TO: THE HON TONY KELLY, THE MINISTER FOR PLANNING
Parliament House, Macquarie Street, Sydney 2000
8.12.10

Re: Jones Bay Wharf Marina Development Pyrmont (MP09_0205)

Figure 2 - View 01 from cliff above Pirrama Road

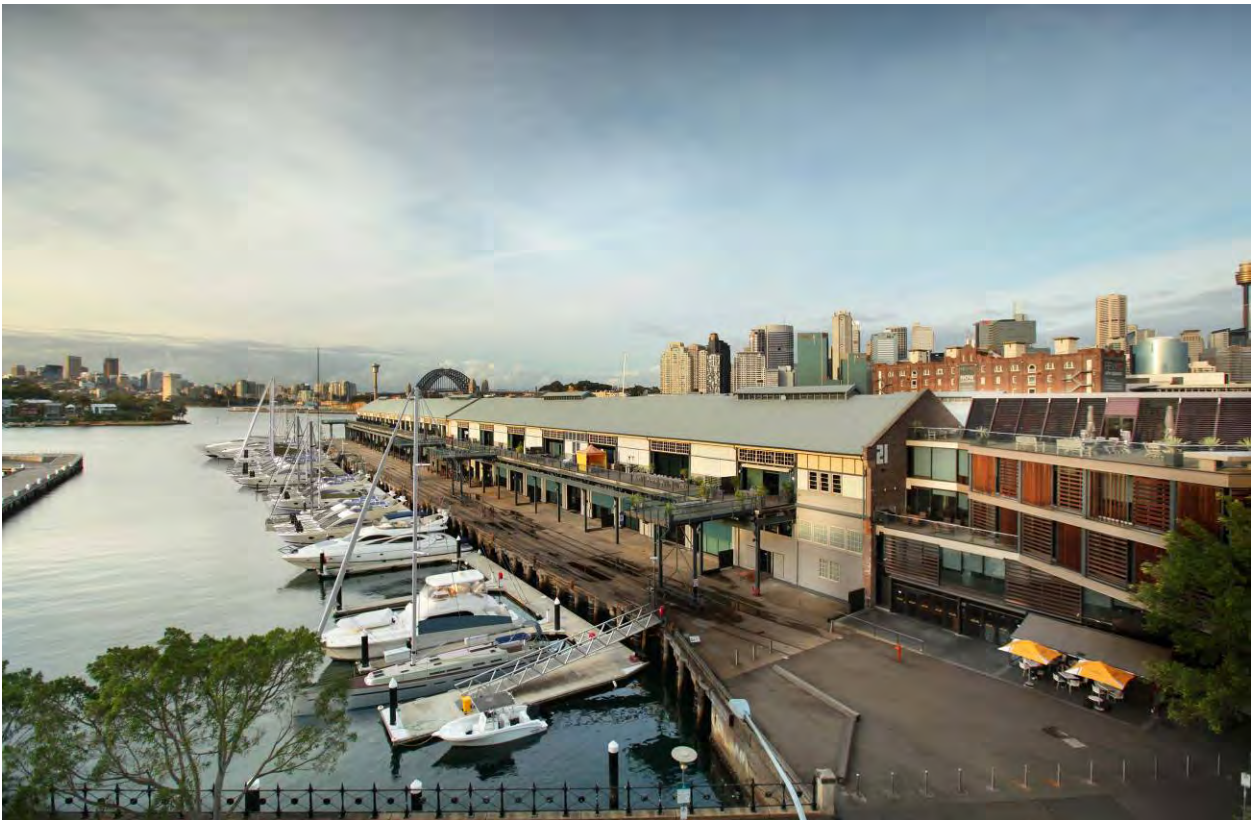
- The scale and number of the vessels will impact on the views from the offices on the wharf and from the surrounding public parks and residences. The James Watkinson Reserve will be seriously affected with a wall of boats wiping out historic public views.
